FROM: Ian Gledhill **TO:** Arun District Council
FAO: David Easton

SUBJECT: P/140/16/OUT - Outline application for access only - mixed use development comprising of up to 400 dwellings, a care home with up to 70 beds, a Local Centre comprising up to 2000sqm of A1/A2/A3/D1/sui generis floorspace, provision of land for a 1FE primary school (with sufficient space to ensure that it is expandable to 2FE), provision of land for a scout hut, safeguarding of land to help link the site to the Pagham Harbour Cycle Route & other community uses including public open space & allotments with some matters reserved. This application is a departure from the Development plan.

Land South of Summer Lane & West of, Pagham Road, Pagham, West Sussex

Figure 5.2 – Proposed northern site access junction

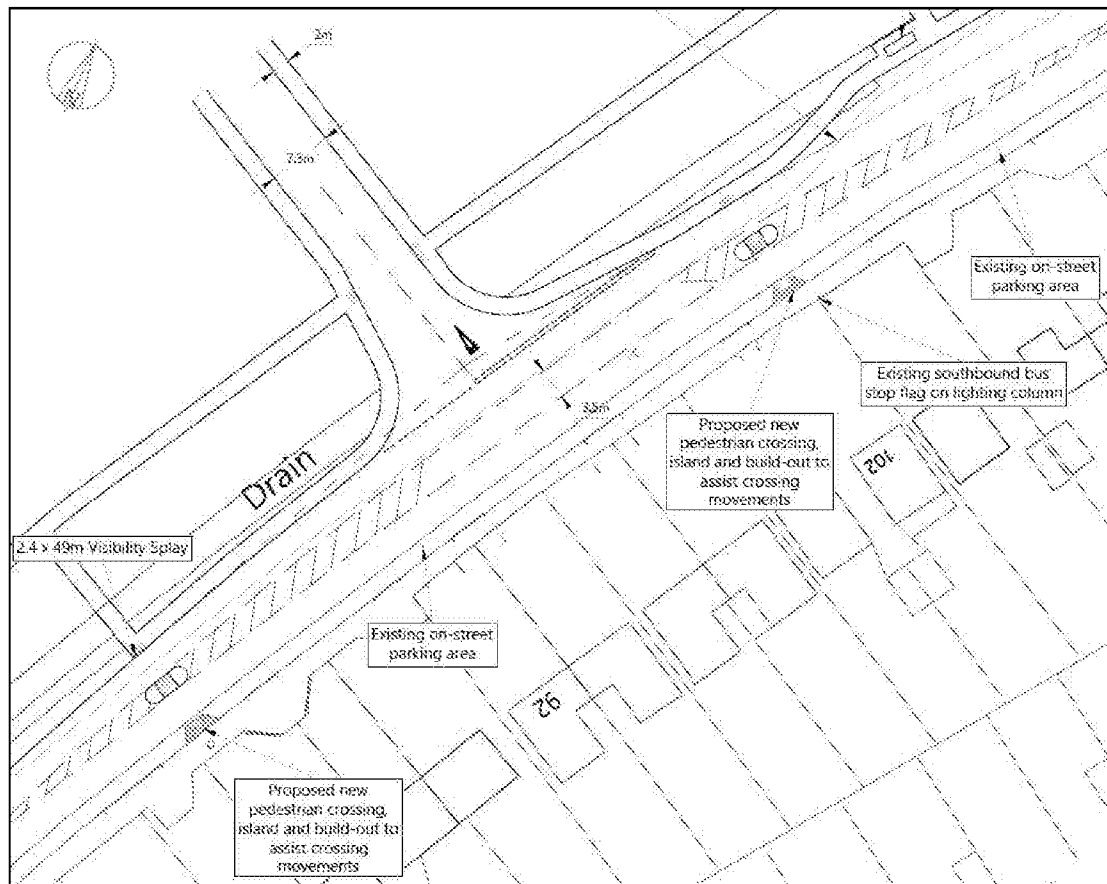
The principle of the vehicular access has been previously accepted. No additional comments are necessary. Several comments were issued in connection with pedestrian access to the development and more specifically the location of crossing points. The arrangements have been slightly revised with the pedestrian crossing moved from south of the Pagham Parish Council to the north; the main issue with the previous arrangement being the location of the build out on the opposite side of the carriageway potentially conflicting with an existing dropped kerb vehicle access. The revised arrangement removes this potential conflict.

Another matter was in connection with problem 2.3.1 raised within the Stage One Road Safety Audit. This problem raised the potential crossing desire line in the immediate vicinity of the northern vehicle access. The Safety Auditor recommended the upgrading of the proposed traffic island to a pedestrian refuge to deal with these demands. The traffic island has now been altered to a refuge. With this arrangement there is the matter of the southwest bound bus stop being adjacent to the crossing point. This matter has not been raised by the Stage One RSA. In the event that there is a conflict or a safety issue raised as part of any subsequent Stage 2 (detailed design) or 3 (undertaken once the access has been built and is in use) RSAs, it's considered that the bus stop could then be relocated.

The only other matter raised by the Stage One RSA was the dimensions of the amended bus stop lay-by on the north side of the carriageway. The designer has confirmed that the dimensions of the lay-by (shown on drawing number 1616/01 Rev K) match those of the existing. This problem is considered to have been addressed.

No use within the northern phase of the development shall be first occupied until such time as the vehicular and pedestrian accesses and bus stop lay by as indicatively shown on drawing 1616/01 Rev K.

Figure 5.3 – Proposed southern site access junction

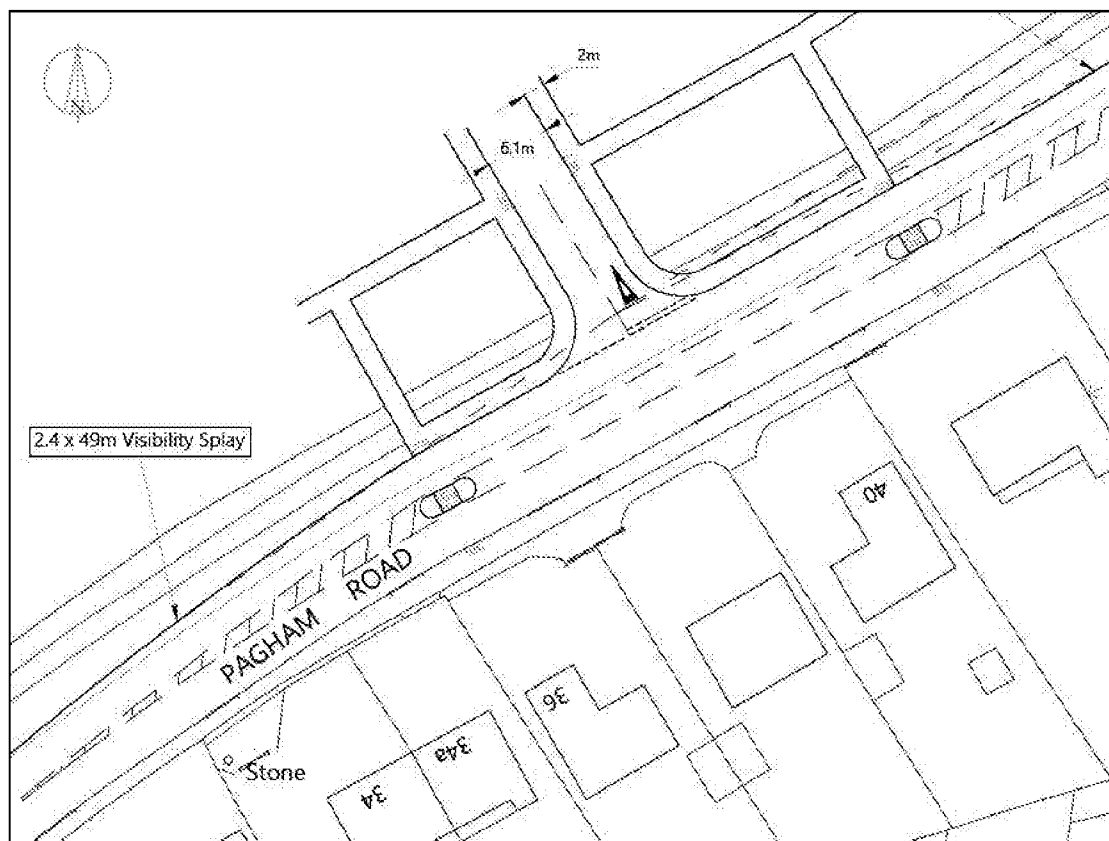
No use within the southern phase of the development shall be first occupied until such time as the vehicular and pedestrian accesses as indicatively shown on drawing 1616/02 Rev J has been constructed.

Figure 13.5 - Proposed mitigation at the B2166 junction with the B2145 (C&A plan ref: 12-018-045/B)

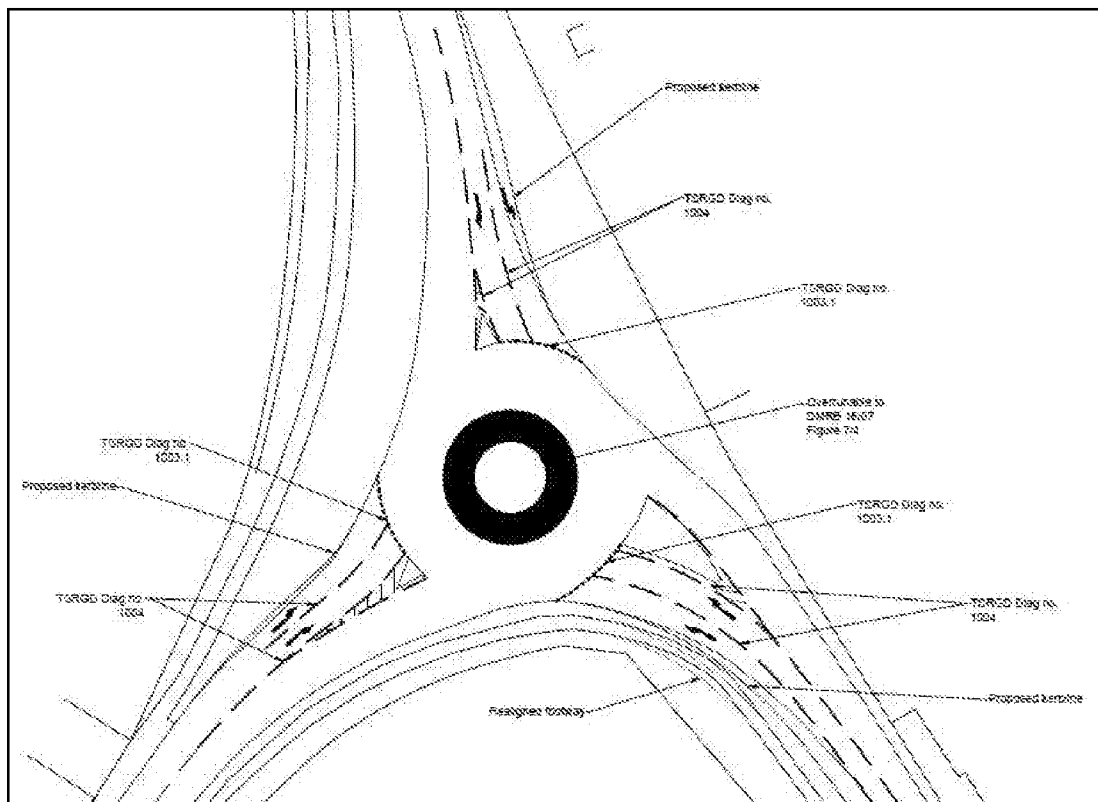
- The safeguarding of land as shown on drawing titled 'Potential Cycle Link to Honer Lane' to enable the provision of a cycleway and improved pedestrian route.
- Proposed improvement works to the B2166/B2145 roundabout as shown on drawing number 1616/13 Rev C or any other such scheme as agreed with WSCC*.
- Contribution of £65,000 towards improvements to the surface of public right of way no. 101*.
- Contribution of £152,245 towards improvements to Pagham Road/B2166 Lower Bognor Road junction or any other works that would mitigate the increased traffic arising from the proposed development. This is referred to within the applicants documents as a 'Contribution to WSCC for sustainable transport measures on the wider highway network'*.
- Contribution of £40,816 towards the upgrading of public rights of way 100, 106 and 104 to enable the creation of an off road cycle route*.
